Gatwick Airport Northern Runway Project

Appendix A – Response on Design Matters

Application Document Ref: 10.58

PINS Reference Number: TR020005

Figure 13. CARE Facility Indicative Ground Floor Plan

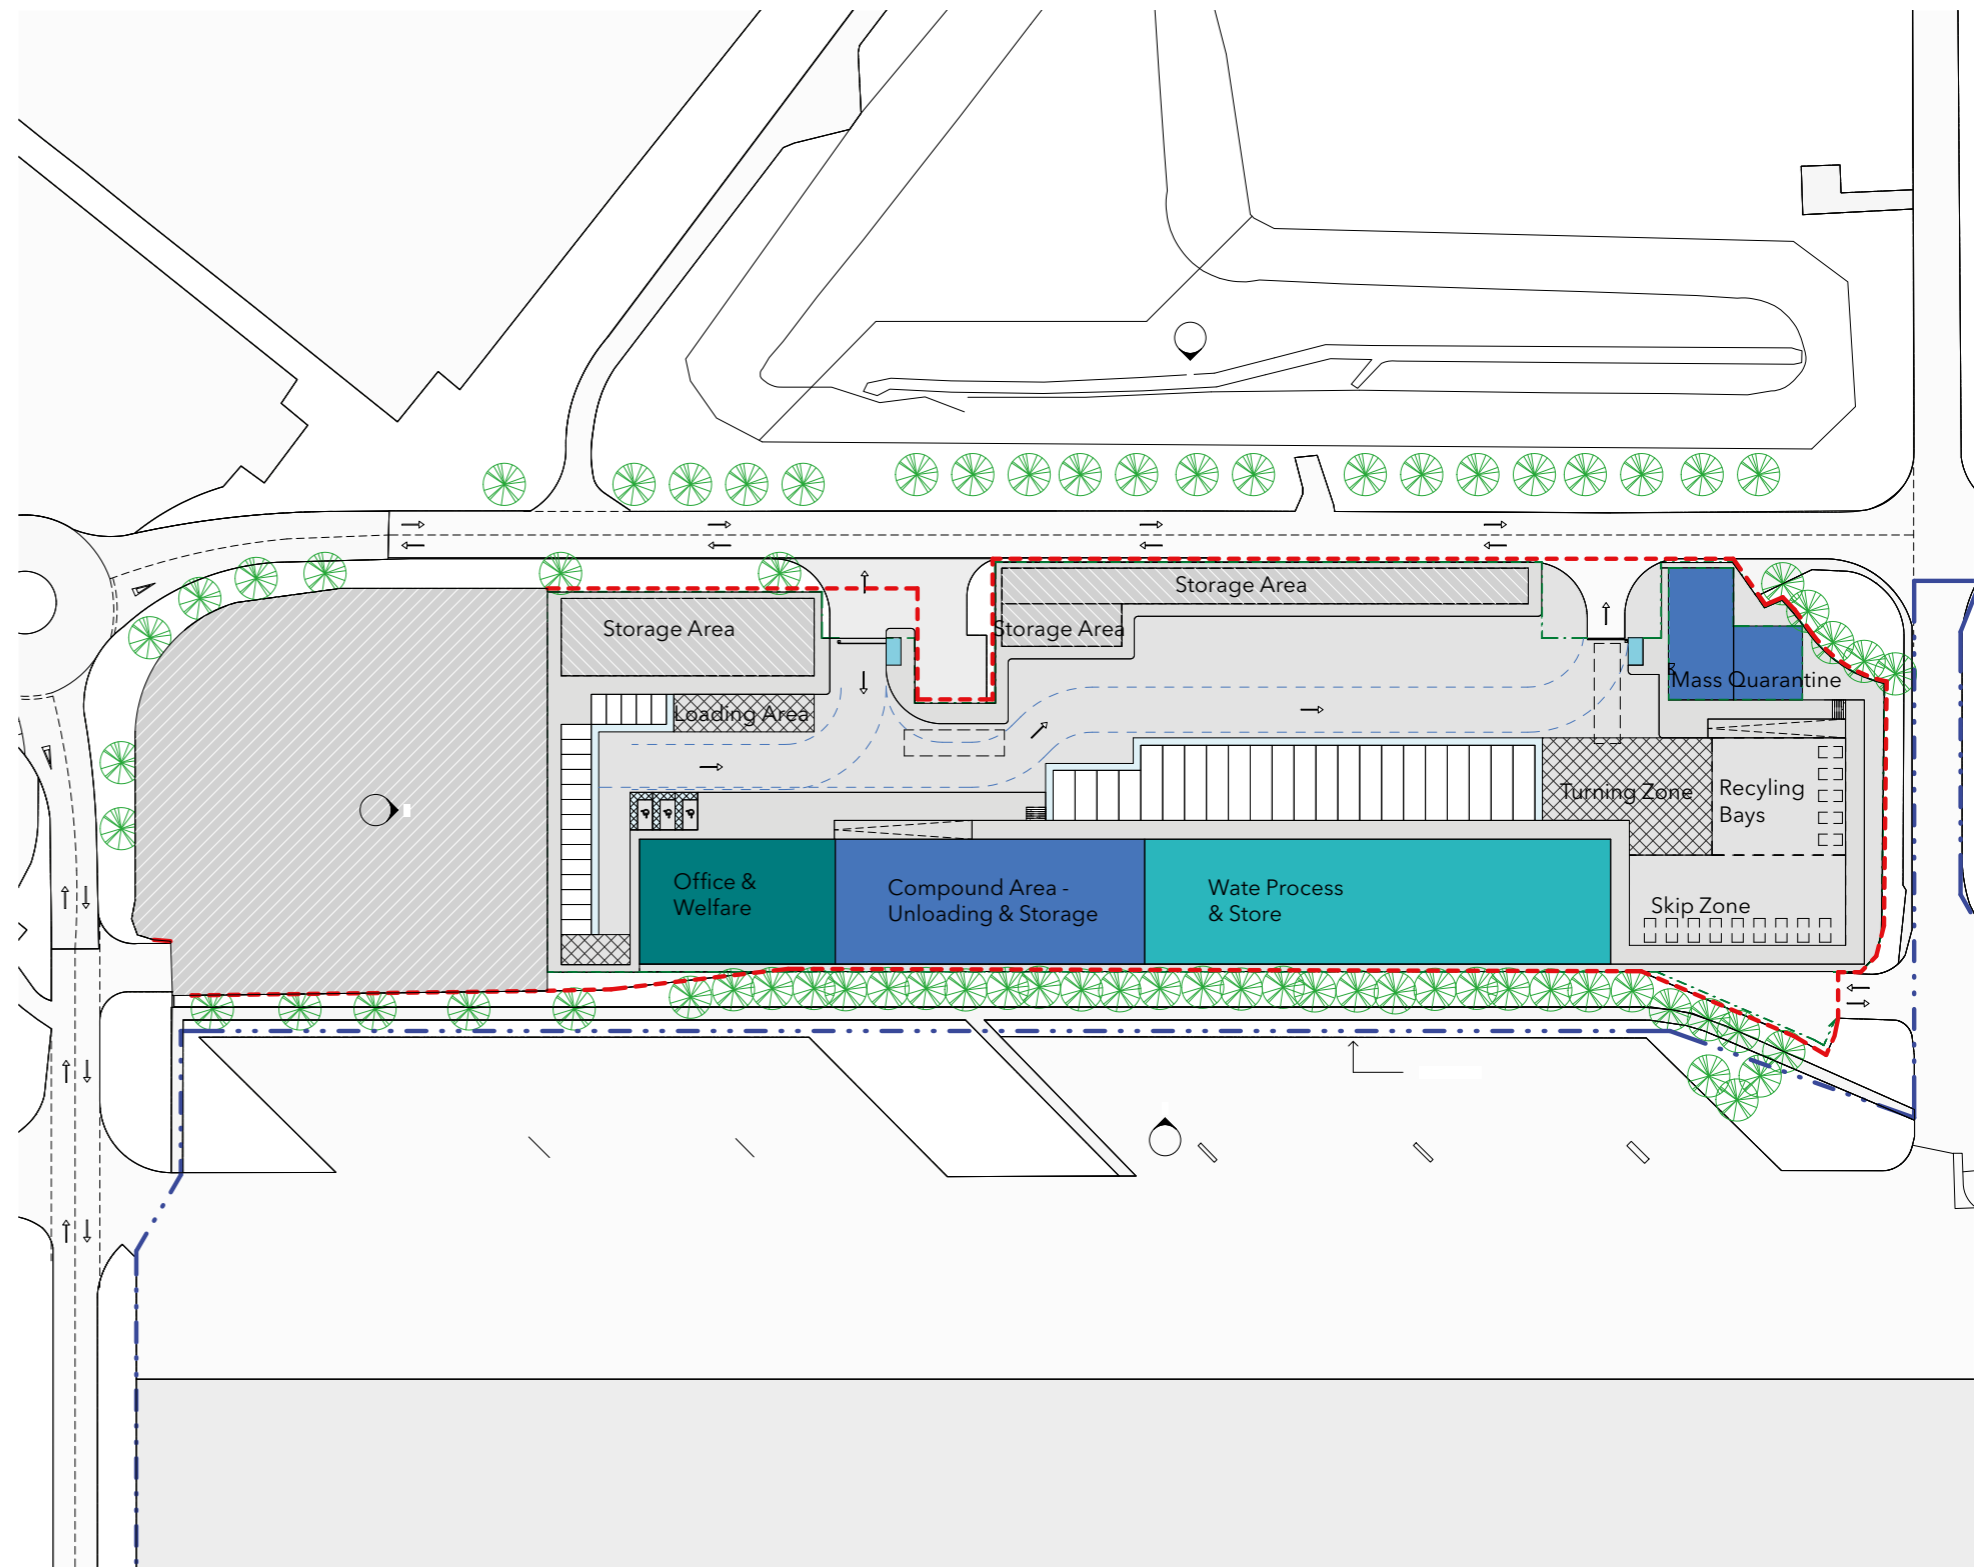
<p><u>Work Nos.7 and 8</u></p> <p>The same point applies in respect of Work Nos. 7 and 8 which are shown together on Sheet 1 of 7 of the Works Plans (Drawing number 20000-XX-A-XXX-GA-990002) (revision P03) –</p>	<p>Work Nos. 7 and 8 are shown together as relating to the same area. Work No. 8 relates to the removal of existing features within this area and Work No. 7 relates to works to be constructed in its place, i.e. the Oscar Area. To assist the LPAs, the Applicant has submitted at Deadline 7 a standalone Informative Sub-Work Plan for Work Nos. 7 and 8 (Doc Ref. 4.11)</p>

<p>Work Nos. 7 and 8 consist of the following works –</p> <p><i>The response contained an extract of the Work Plan and Work Nos. 7 and 8 descriptions, which are not repeated here.</i></p>	<p>which shows the components (a) to (c) of Work No. 7 alongside the components (a) to (g) of Work No. 8.</p> <p>Notwithstanding this, it should be noted that the proposed components under Work No. 7 are clearly shown on ES Figure 5.2.1a: Proposed Airport Works [REP6-015] and similarly the works to be removed under Work No. 8 are clearly shown on ES Figure 4.2.1a: Existing Airfield Infrastructure [REP1-019].</p>
<p><u>Work Nos. 9, 10 and 14</u></p> <p>The same points made above apply equally to these Work Nos.</p>	<p>In response to the LPAs’ comments, the Applicant has submitted at Deadline 7 standalone Informative Sub-Work Plans for Work Nos. 9, 10 and 14 (Doc Ref. 4.11). An explanation of what is shown on those plans is provided below.</p> <p><u>Work No. 9</u></p> <p>The Informative Sub-Work Plan distinguishes between individual elements where possible at this stage of the design work. Notably, parts (a), (c) and (e) have been marked. It is not possible to distinguish the remaining parts further at this stage of the design work (even on an informative basis), as the positioning of the card baling facilities and the baled waste storage area has not been finalised at this stage. All of these features will be contained within the overall extent of the premises, which will comprise a hardstanding area, as defined under part (f). As such, parts (b), (d) and (f) remain grouped together on the Informative Sub-Work Plan.</p> <p>Figure 13 of the Design and Access Statement Volume 3 (Doc Ref. 7.3) provides an indicative ground floor plan of the replacement CARE facility.</p>
